Recommendation Report for Listed Building Consent for Alterations, Extension or Demolition of a
Listed Building

REF NO: AB/26/18/L

LOCATION: The Swan Hotel
27-29 High Street
Arundel
BN18 9AG

PROPOSAL: Listed building consent for replacement of the existing external signage scheme

PROPOSED ELEVATIONS

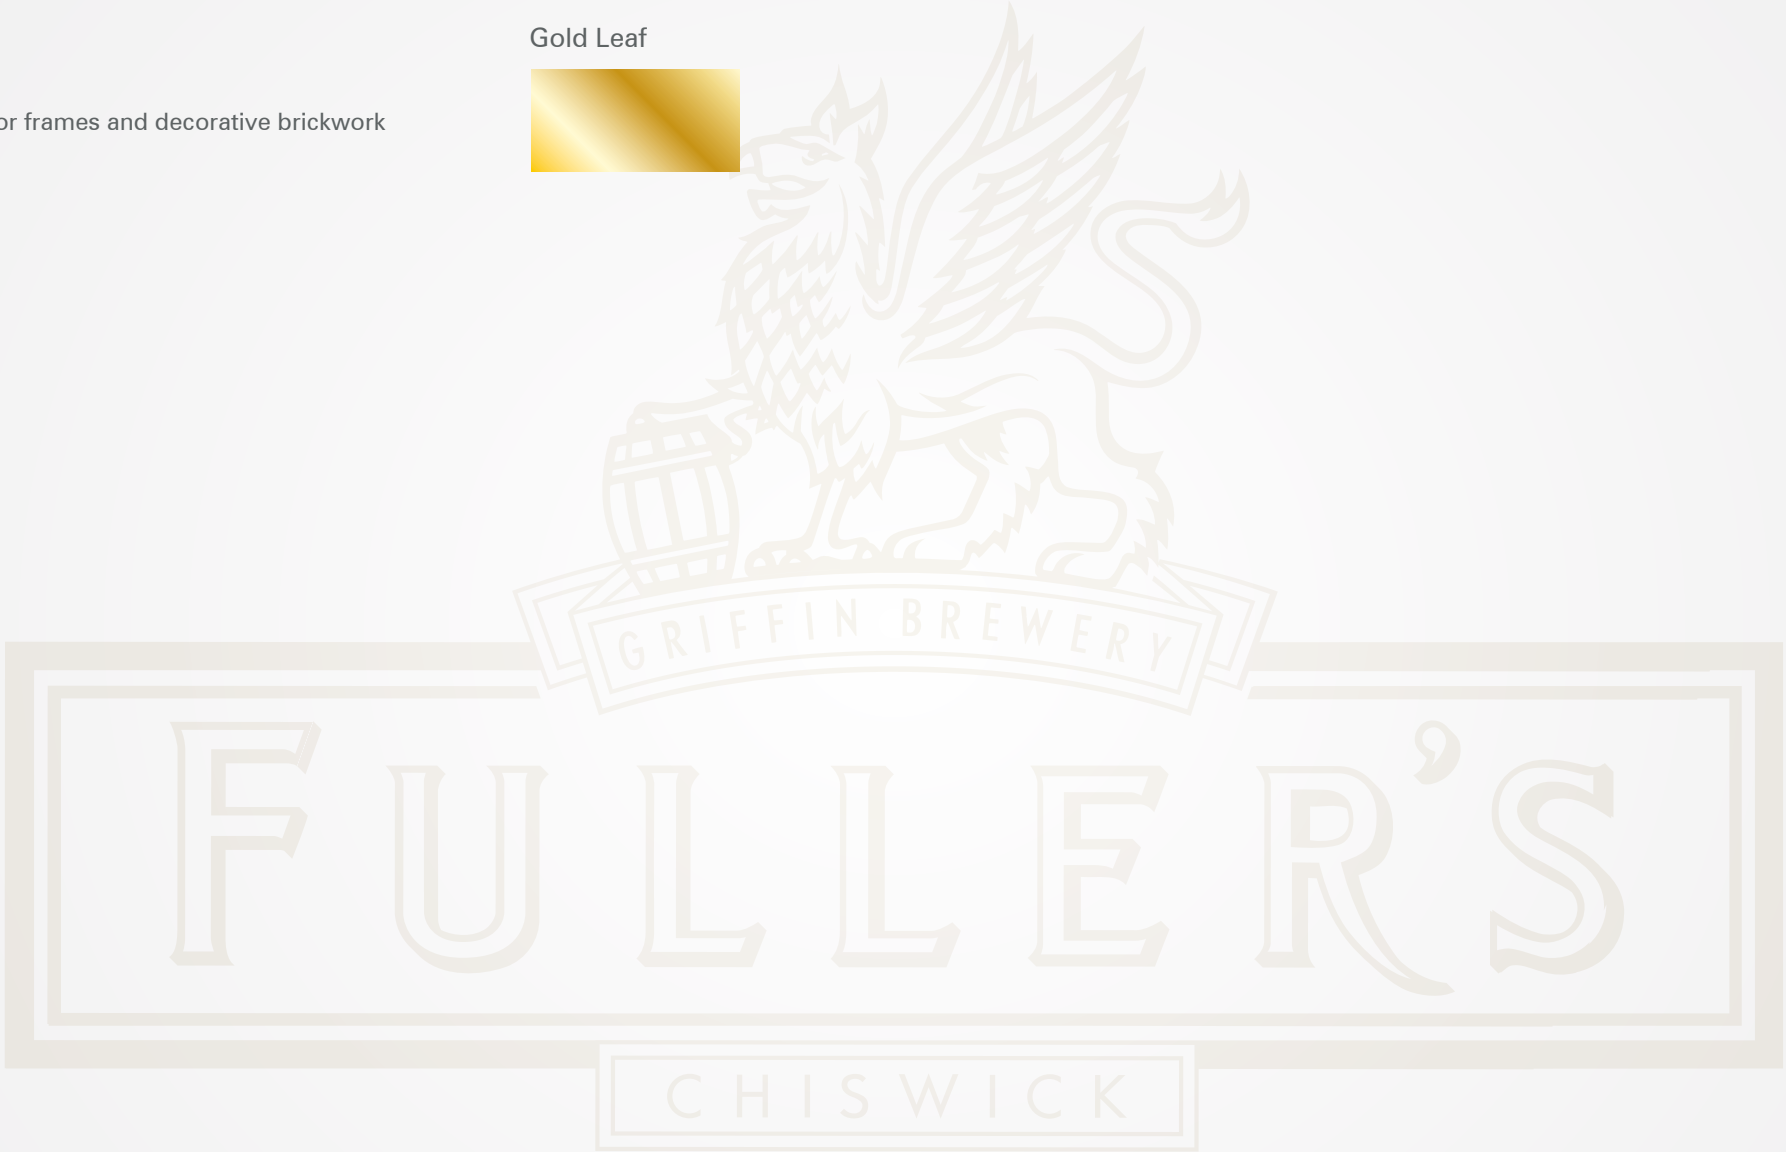
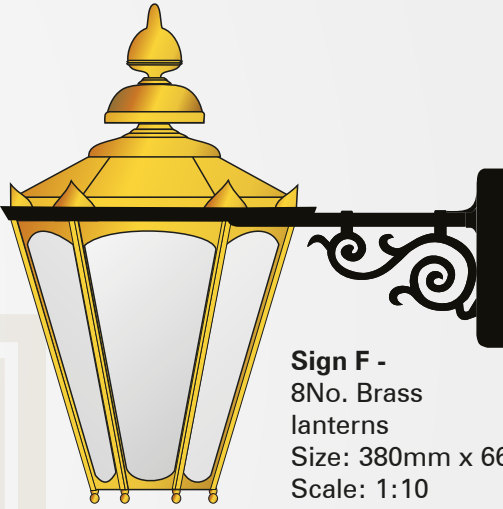
It should be noted that through the various amended plans the originally proposed metal work sign has been removed and a more traditional painted board sign has been proposed. Officers including the current Conservation Officer Consider this acceptable and in keeping with not only the host building but also the Conservation Area.

The Previous Conservation Officer considered the current level of lighting to be sufficient to illuminate signage and that there be no net increase of external illumination. Officers note that the current plans, Issue 7, remove a number of the originally proposed signs to reflect this.
